Re: Framing Items
Location: Lot 1 Griffon Pointe (2371 Old Us 421 (Lillington, NC))
JDS Project No.: RDU2311797
Date of Inspection: 12/7/23

A representative of JDS Consulting arrived on site to observe the issues reported to us by the client, which are presented, along with our recommendations, in this report.

SHEET NO.
 S3

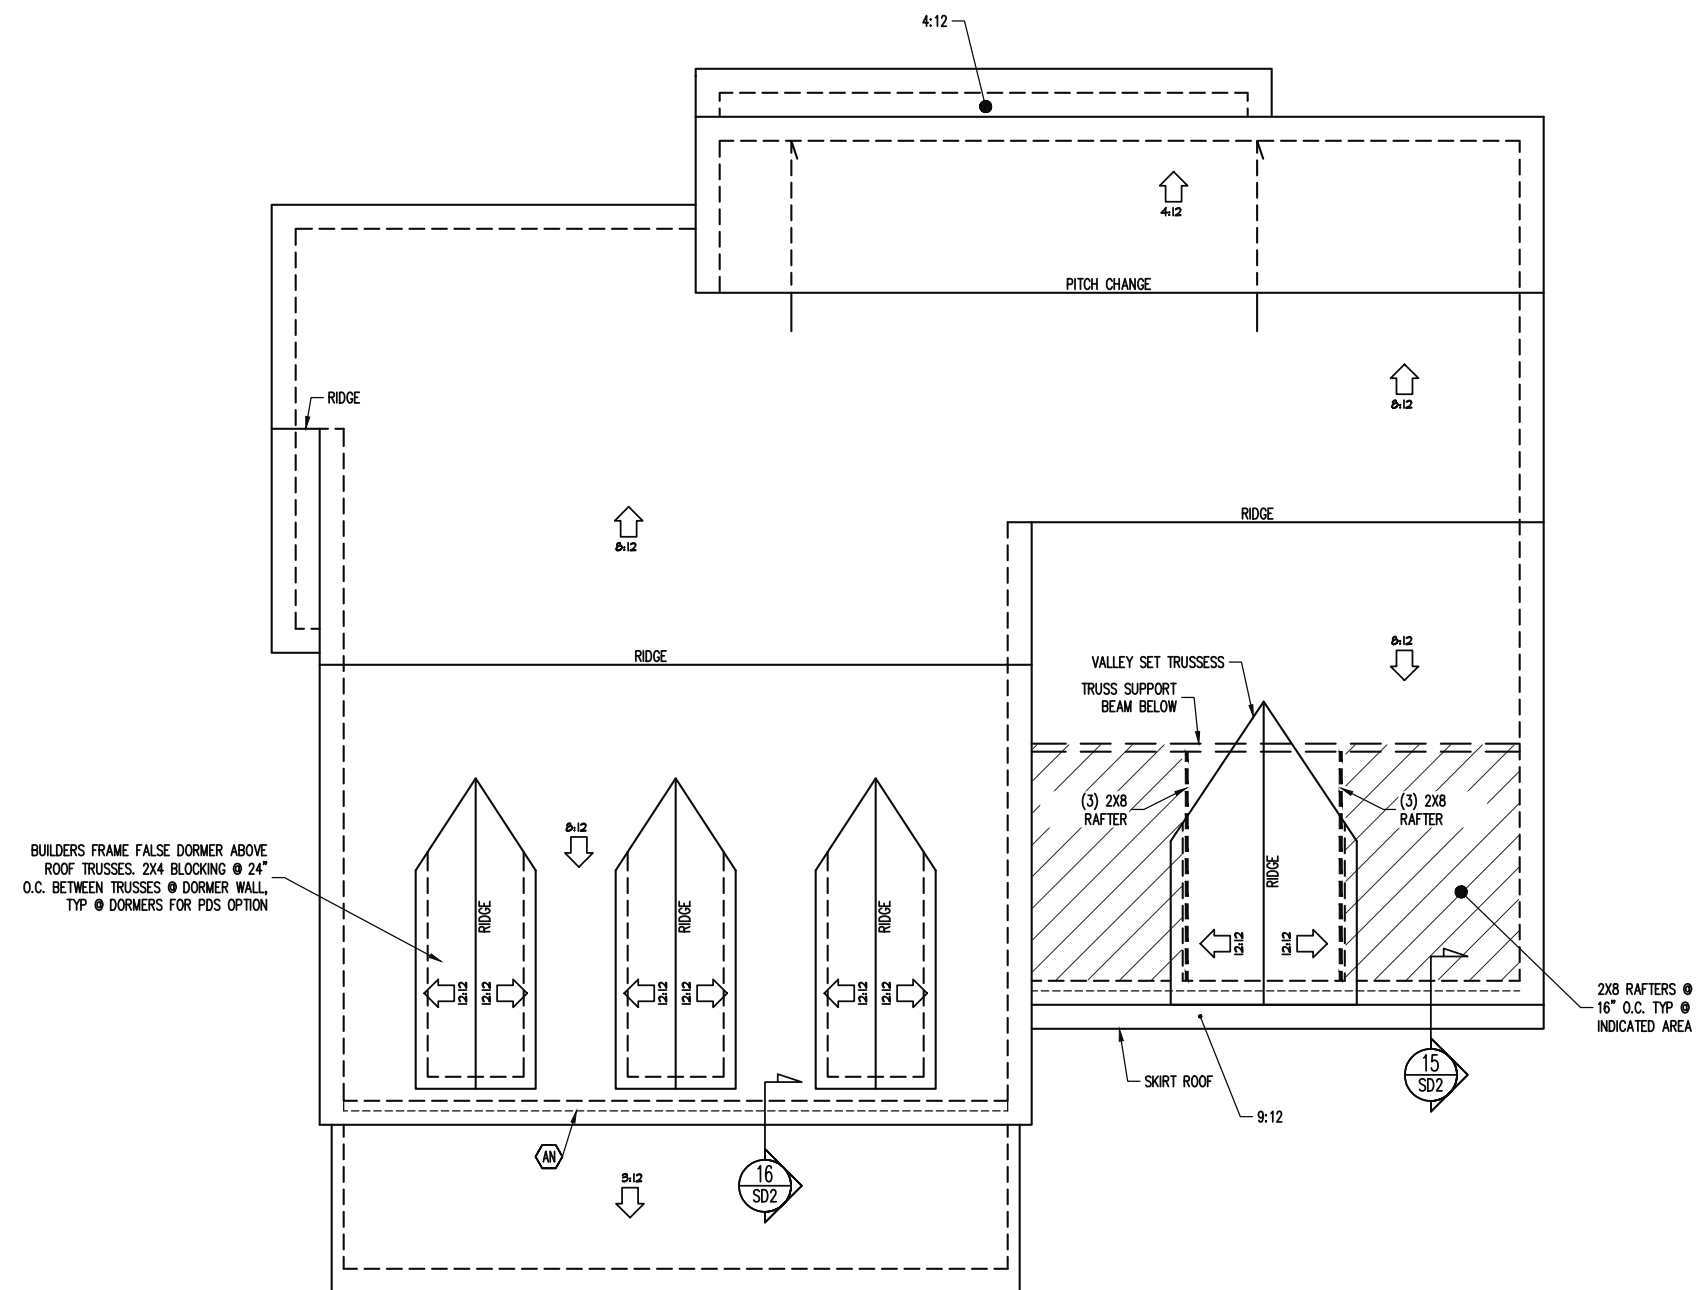
1. The contractor has installed (2) 2x10's as headers to the left and right of the foyer in lieu of the (2) 1 ¾" x 9 ¼" LVL called for on the plans page S3.
2. The balloon framed wall at the left of the stairway has been built with (2) 2x4's spaced 12" O.C. in lieu of 2x6 16" O.C. called for on the plans page S3.
3. At the right and left end of the (3) ply LVL above the front right bedroom and the laundry room the contractor has installed (2) 1 ¾" x 9 ¼" LVL's in lieu of (2) 2x10 per plans.

1. Temporarily support the floor trusses above the headers. Remove the in place (2)2x10 headers at both locations and replace with (2) 1 ¾" x 9 ¼" LVL's.
2. Install (2) rows of ¼" x 5" SDS screws in every other wall stud 12" O.C. equidistantly spaced within the 2x10 stairway platform.
3. The use of the (2) 1 ¾" x 9 ¼" LVL's in lieu of (2) 2x10's is adequate as installed. No further action is required.
